Re: **Bradley Heights PUD Development Plan** – Third Review Comments **File # AR PUD 21-00206**

We are in receipt of your review letter dated November 24, 2021. Below is a point by point response to these comments prepared in coordination with the Developer (Challenger Homes) and the Design Team (HRG). New comments are indicated by **purple font**.

### PUD Development Plan

PUD DEVELOPMENT PLAN
PUBLIC UTILITY & FACILITY PLAN - NORTH

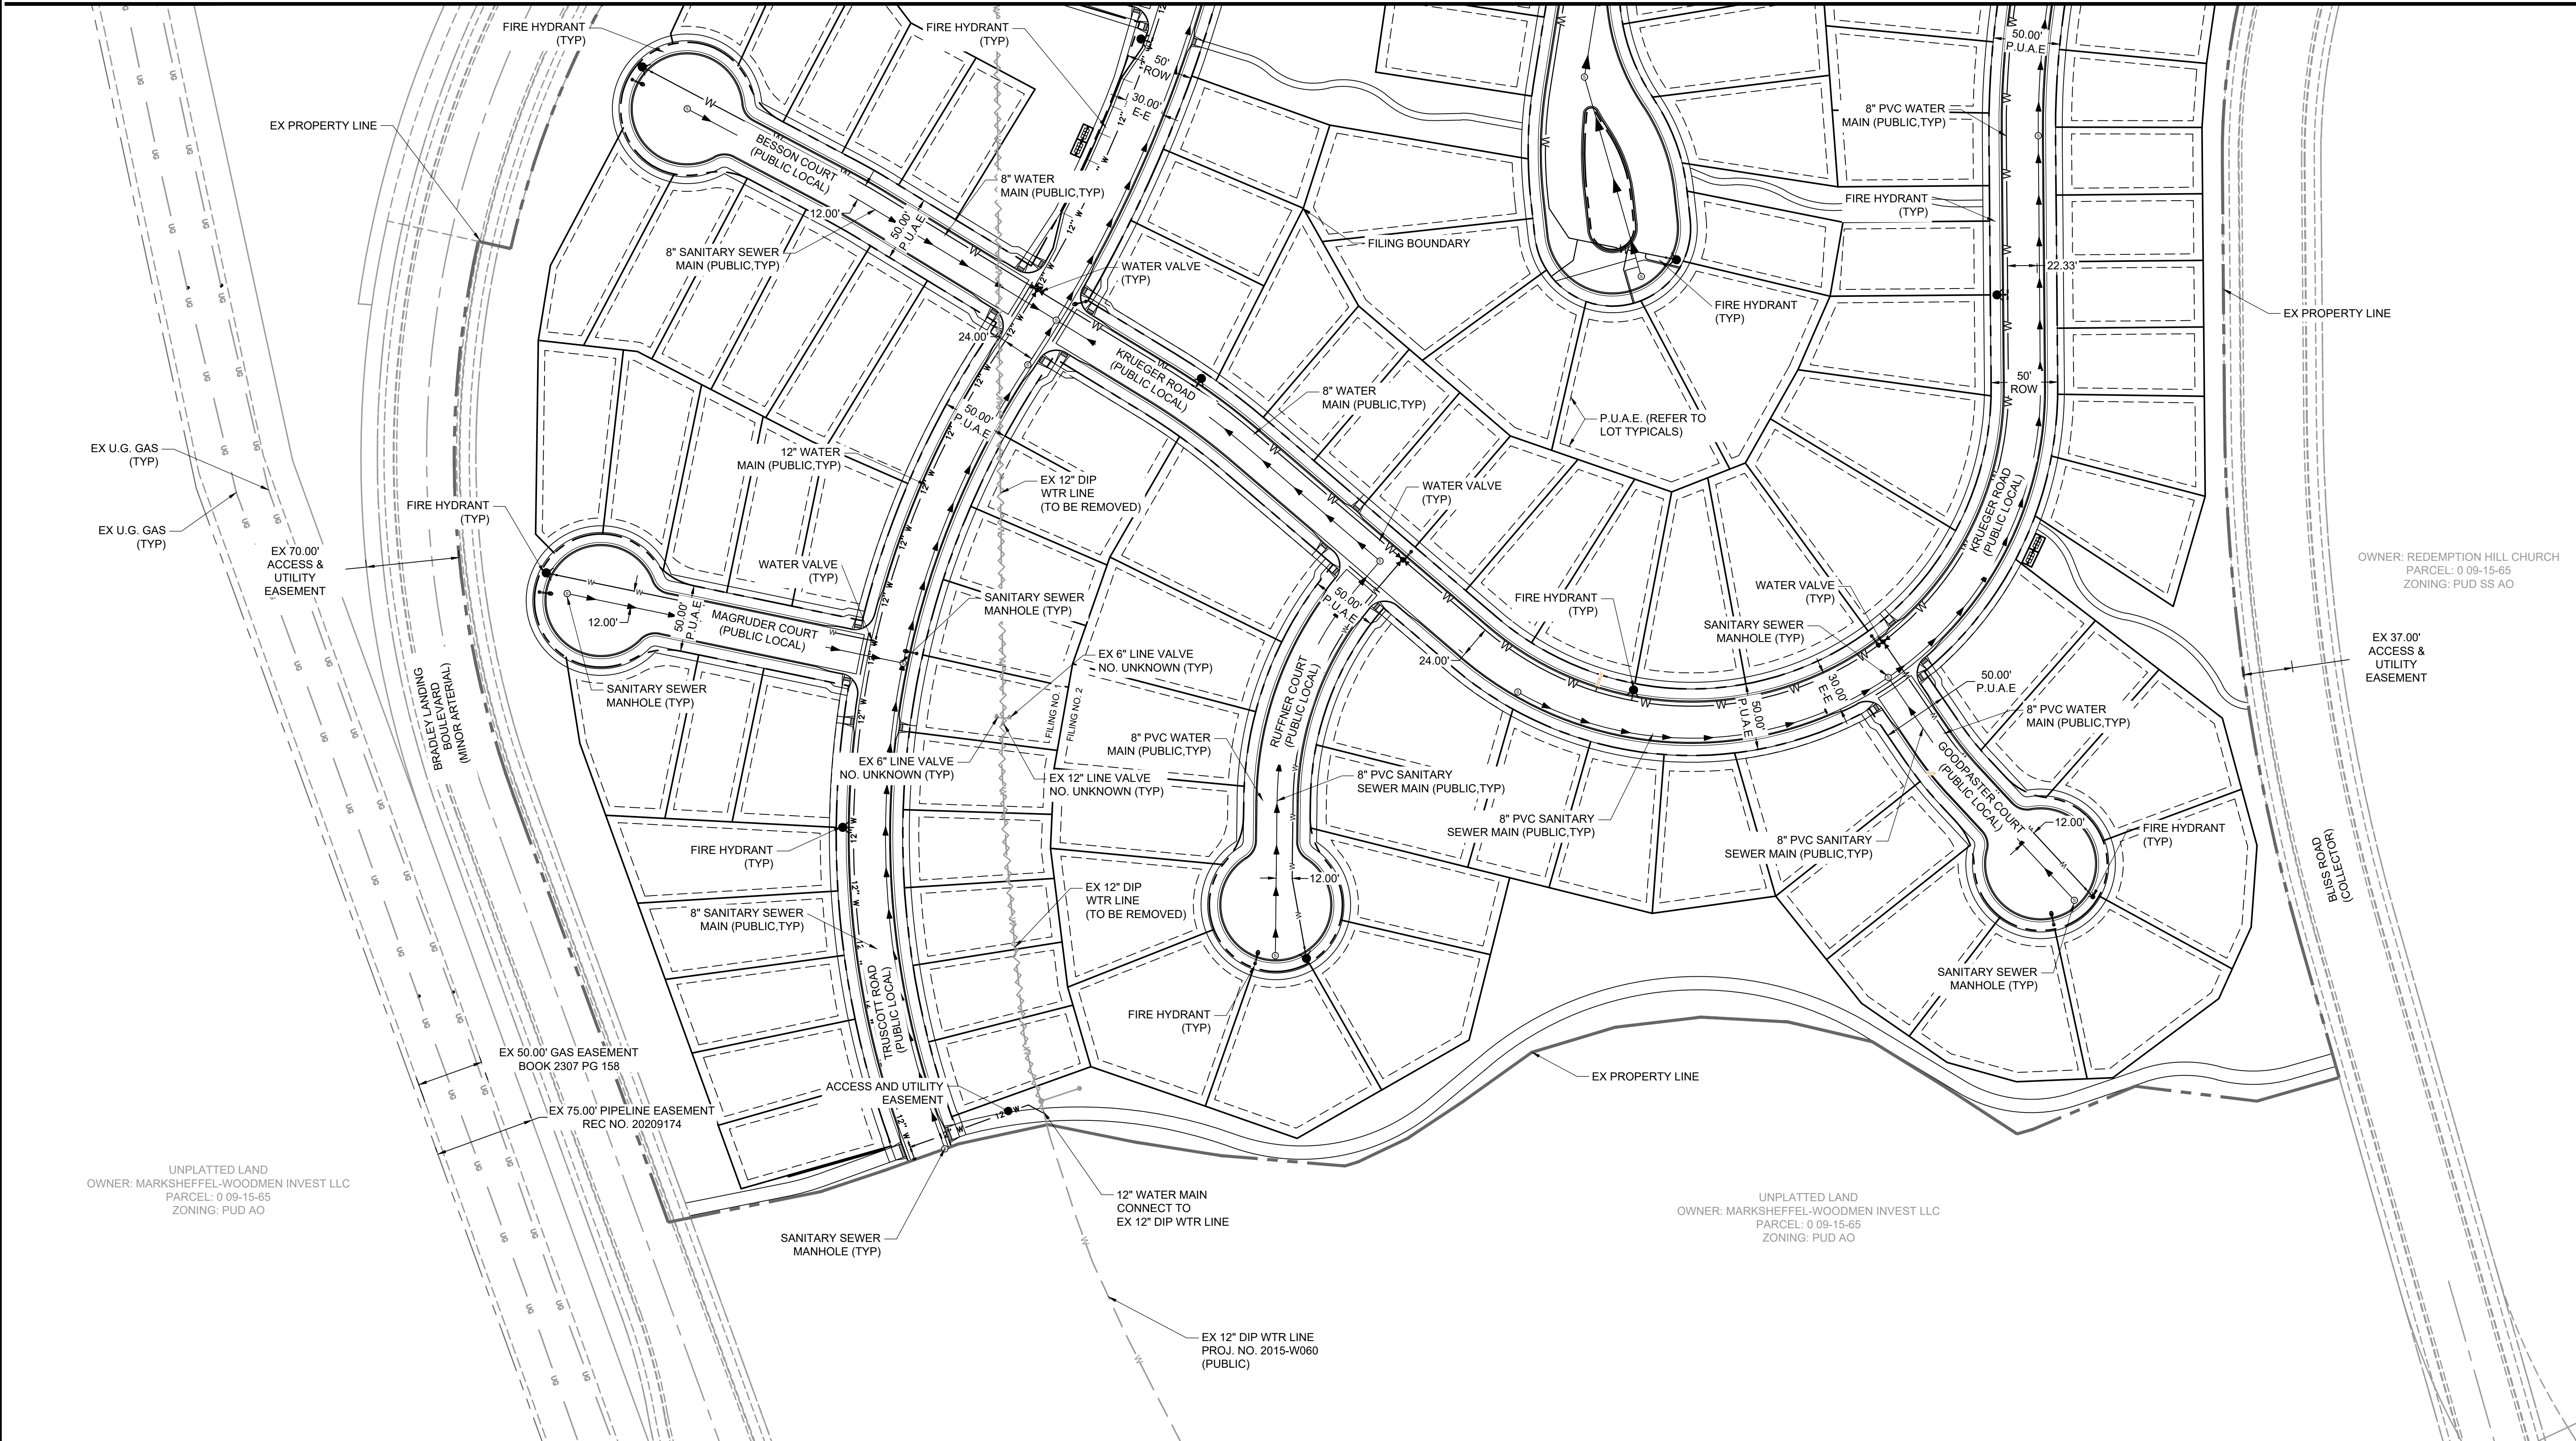
1. Please call out on the utility plan which utilities are CSU, and which utilities are Centre within Bradley Road.  
**RESPONSE (HRG): Addressed. All water and sewer is to be owned by CSU. Additional labeling has been added to plans to clarify construction responsibility and ownership.**

2. What does the dark blue dashed line mean on your utility drawing? Please show this in a legend and call out on plan.  
**RESPONSE (HRG): Filing boundary. Added to legend.**

5. You propose a new wastewater main within Bradley Rd, and it looks like it is feeding from the west, and it connects to the proposed CSU wastewater main for this development. Where is this line coming from and who owns this line?

6. Proposed manholes cannot be within the curb and gutter pan.  
**RESPONSE (HRG): Noted. Manholes removed from curb and gutter.**
7. You will need to design the proposed utilities to the current cross section standards. Please reference the criteria at [www.csu.org](http://www.csu.org). If you have any questions, you can reach out to me at [ajuvera@csu.org](mailto:ajuvera@csu.org)

9. You will need to show the lot numbers on the utility plan.  
**RESPONSE (HRG): Lot numbers added to plan.**
10. You will need to show the current cross section on the utility plan for each proposed right of way where you propose utilities.

13. Call out a note on both side of your plan that you are connecting to the future 24-inch water main.  
**RESPONSE (HRG): Noted added clarifying utility connections. Please note the connection to future 24-in water main will be by BHMD and is not a part of this project.**

15. How are you tying into the existing wastewater main in Bradley Rd? Call this information out on the plan view.  
**RESPONSE (HRG): Connection is completed with a new 5' manhole. Please note connection being constructed by BHMD (separate project) but is shown here for reference only.**

16. The proposed storm within Bradley Road will need to be 10 feet off of the 24-inch water main.  
**RESPONSE (HRG): The displayed alignment of the 24" line is conceptual. It is our understanding that Classic Engineering is currently designing this main, thus the final location and separations will be determined based on their ongoing design.**

17. Two PRV is required where you connect to the 24- inch water line one at Bradley Landing and the other at Bliss Road.  
**RESPONSE (HRG): The PRVs have been added per the design plans prepared for the BHMD.**

19. We don't need this connection to the existing 12 water line on the south portion of your site. Please remove off drawing.  
**RESPONSE (HRG): Addressed, connection removed. The water line in Magruder Court has been extended to connect to the proposed 12 inch line proposed within Bradley Landing Blvd. thus proving and interim loop for the system until such time that the BHMD completes the additional water line extensions to the southeast.**

20. Reference drawing some of the street name text is covering up proposed manholes.  
**RESPONSE (HRG): The street names label have been adjusted to avoid this where possible.**

21. The proposed sewer cannot go through the island area.  
**RESPONSE (HRG): Addressed, sewer alignment revised out of island.**
22. Add a vicinity map to the utility plan sheet.

**RESPONSE (HRG): The wastewater main in Bradley Road is existing and is currently owned by the Colorado Centre Metropolitan District. See CSU project number 2015-S031. The sanitary sewer in Bradley Landing Boulevard and Bliss Road will be constructed by BHMD and the Bradley Heights 1 & 2 will connect to these lines. It is our understanding that all of these proposed wastewater mains will be owned by CSU.**

**RESPONSE (HRG): Addressed. Utility cross sections updated.**
8. Make sure you call out and show all retaining walls on the utility plan.  
**RESPONSE (HRG): Addressed, all retaining walls shown and called out on utility plan.**

**RESPONSE (HRG): The water main alignment has been revised per the meeting and is consistent with our design efforts that have been coordinated with current Construction Drawings for the water and sewer lines proposed within Bradley Landing Blvd and Bliss Road which have been submitted to CSU for review by the BHMD.**
